ref: 22/00336/F resubmission of
21/00565/F

Extract from **Consultee Responses** to Planning Application **21/00565/F** –
1 Meadow Crest Cottages Street Through Burdrop Burdrop OX15 5RQ

Subject: Planning Application 21/00565/F - 1 Meadow Crest Cottages Street
Through Burdrop Burdrop OX15 5RQ

Description: Part two storey, part single storey rear extension thatched canopy to front door and internal renovations.

Existing & Proposed
 Site Plans

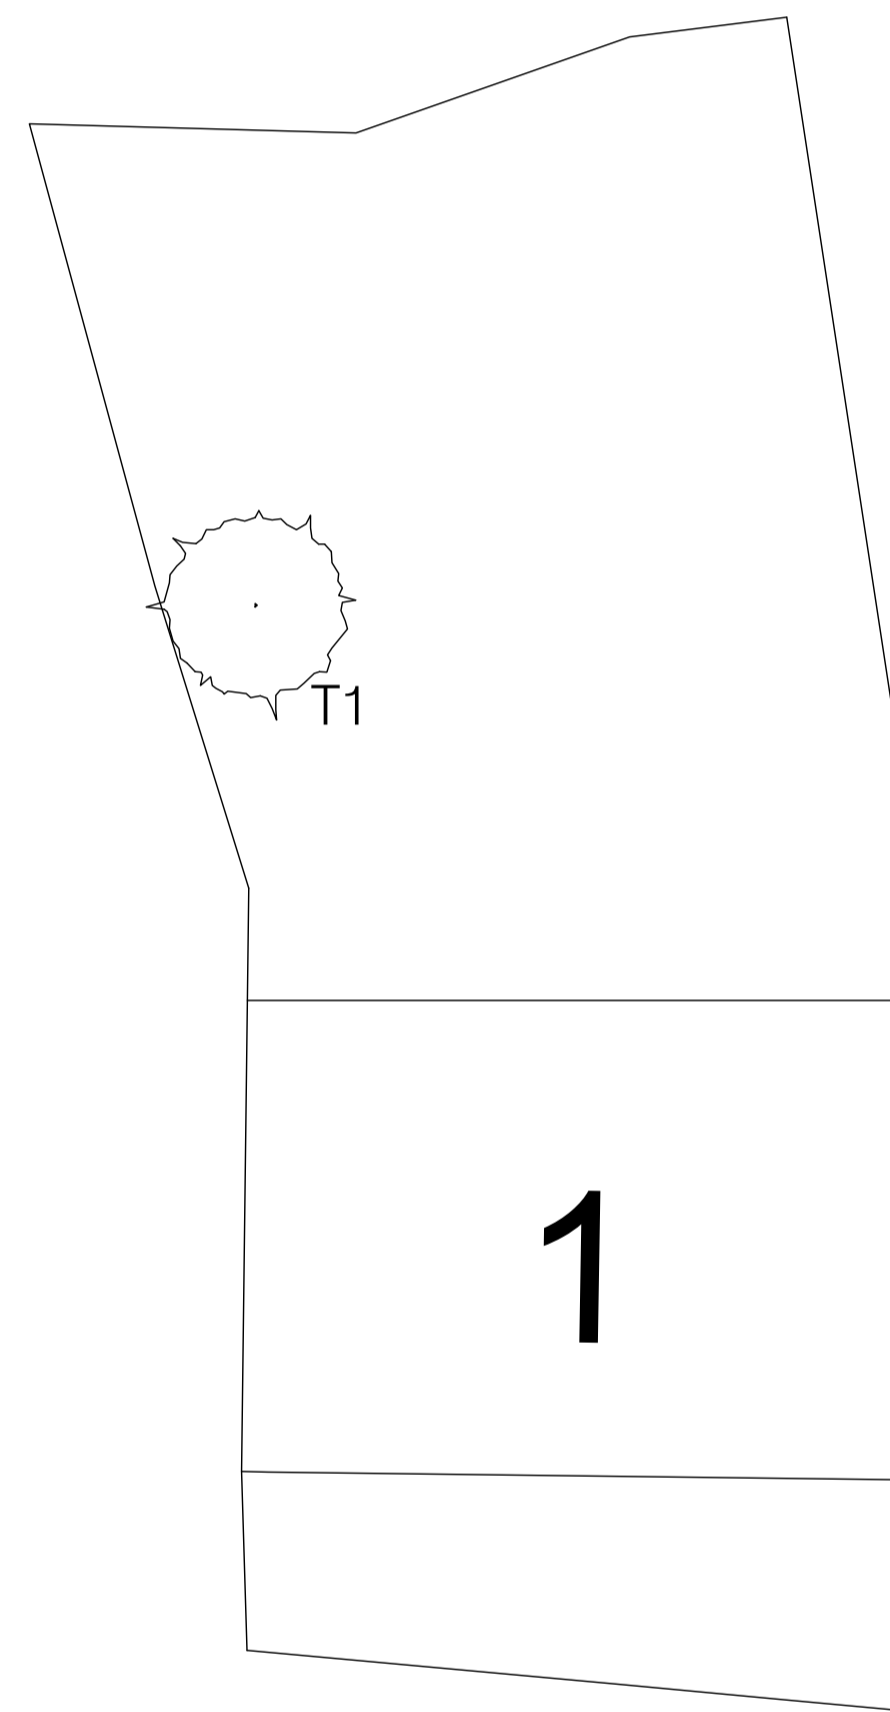
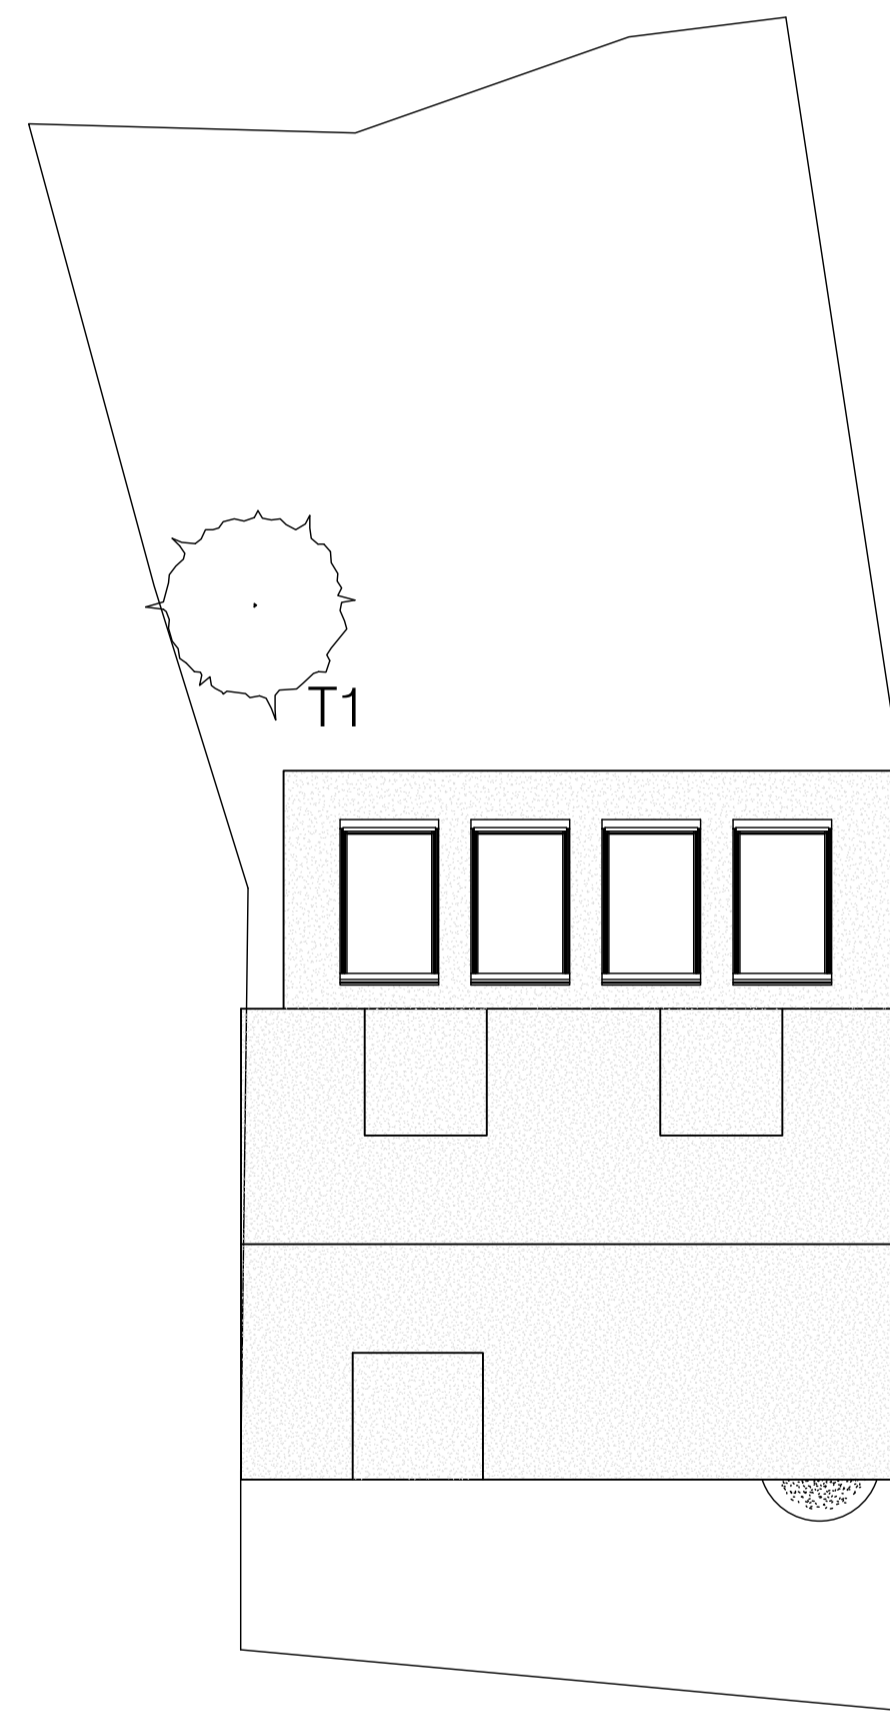
Comments: The proposal is for a substantial ground floor, first floor and second floor extension and alterations to an existing modest two-storey, two-bedroom and two-reception room dwelling. The site does not have the benefit of any off-street parking, nor does it appear do any of the other attached thatched properties here. It is therefore presumed the only parking available for this and the adjoining dwellings is on the existing highway network.

Turning to the existing limitations of the site here, it is unfortunate that the existing modest dwelling has no apparent formal off-street parking provision, but given the above identified highway constraints, I am concerned that by permitting a substantially larger dwelling here, and with the creation of an additional bedroom, this could lead to further intensification of the existing, limited on-street parking demand, along what is already a very constrained stretch of the local highway network here.
